SSD-13475973 -706 MOWBRAY ROAD LANE COVE NORTH (Lot 10 1179953)

Thank you for the opportunity to comment on the detailed design for the construction and operation of a Data Centre at 706 Mowbray Road West, Lane Cove North.

**Figure 2 Height Plane Diagram from the Southwest Aspect** (Source: Greenbox Architecture, 2022)

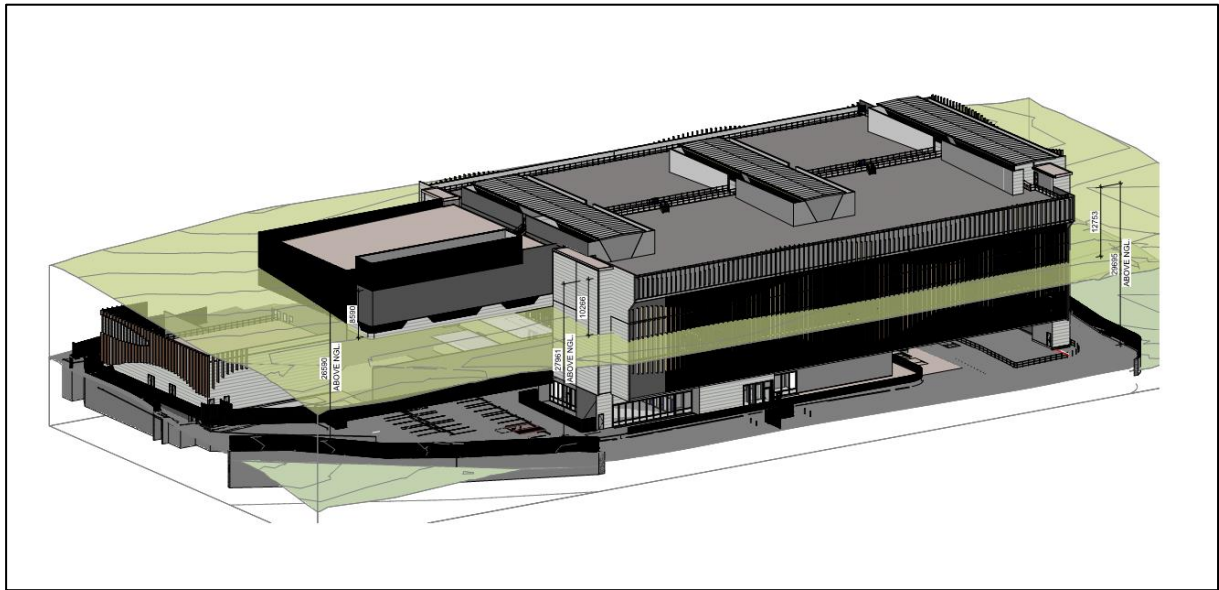
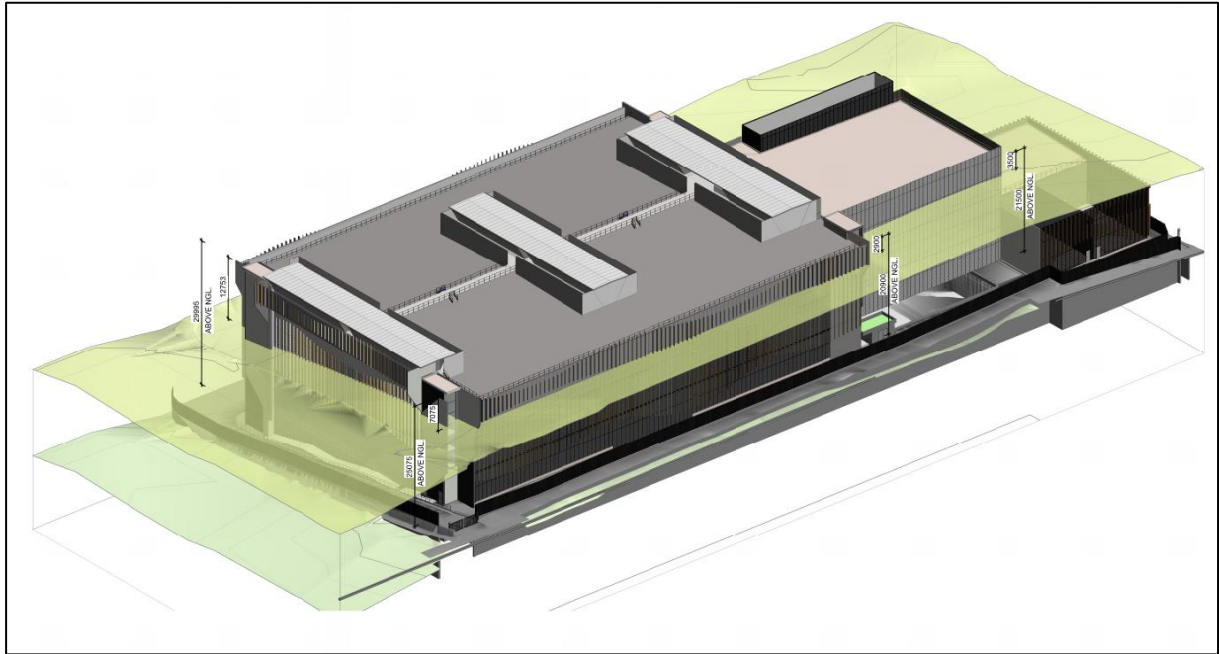
The proposed maximum building height of 29.695m exceeds the Lane Cove LEP control of 18m by 11.695m (64.97% variation). The applicant has submitted a clause 4.6 variation in support of the height variation.

It is acknowledged that the built form has been reduced since the previous scheme. However, the amended scheme is still not supported by Council for the reasons above. It is recommended that the consent authority request the proposed building height be reduced to comply with the 18m height control.

Figure 4 Proposed Northern and Eastern Elevations (Source: Greenbox Architecture, 2022)

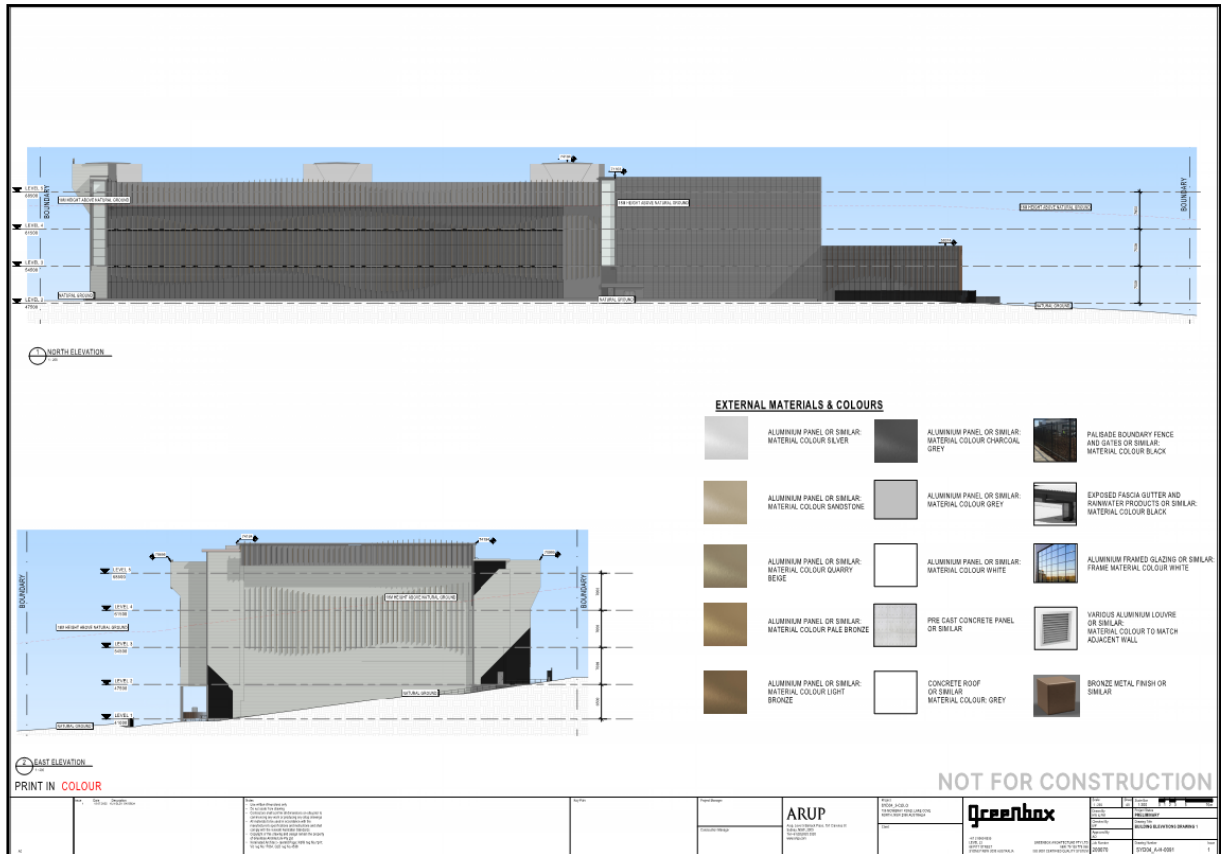
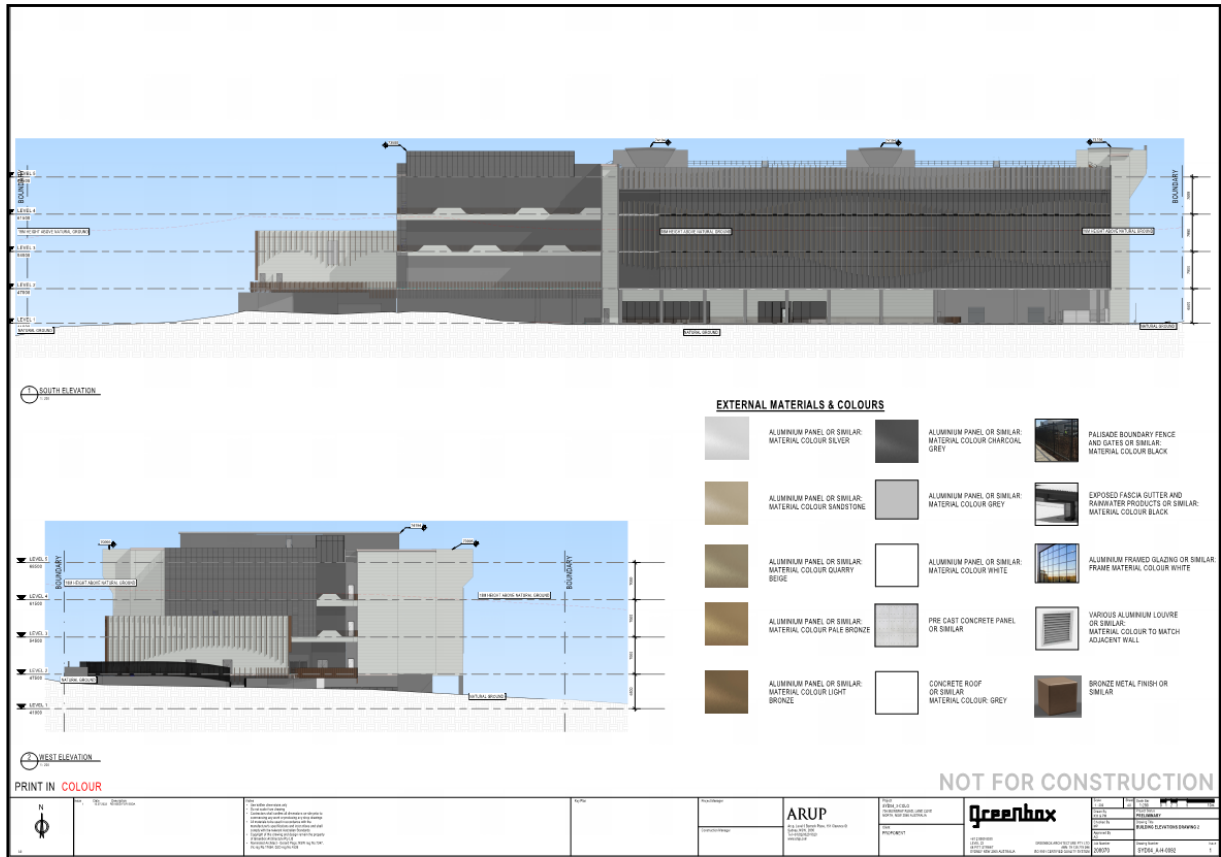
The proposed bulk and scale is out of character with the surrounding buildings in the area. The northern side of Mowbray Road is characterised by single and 2-storey dwelling houses. The current building at 706 Mowbray Road contains a part two and three-storey commercial/light industrial building. The ground floor is below street level of Mowbray Road. The proposed bulk of the data centre would be significantly larger than the existing building and would dominate the streetscape. The visual impact of the proposed built form would be further exacerbated due to the removal of significant trees in proximity to the data centre.
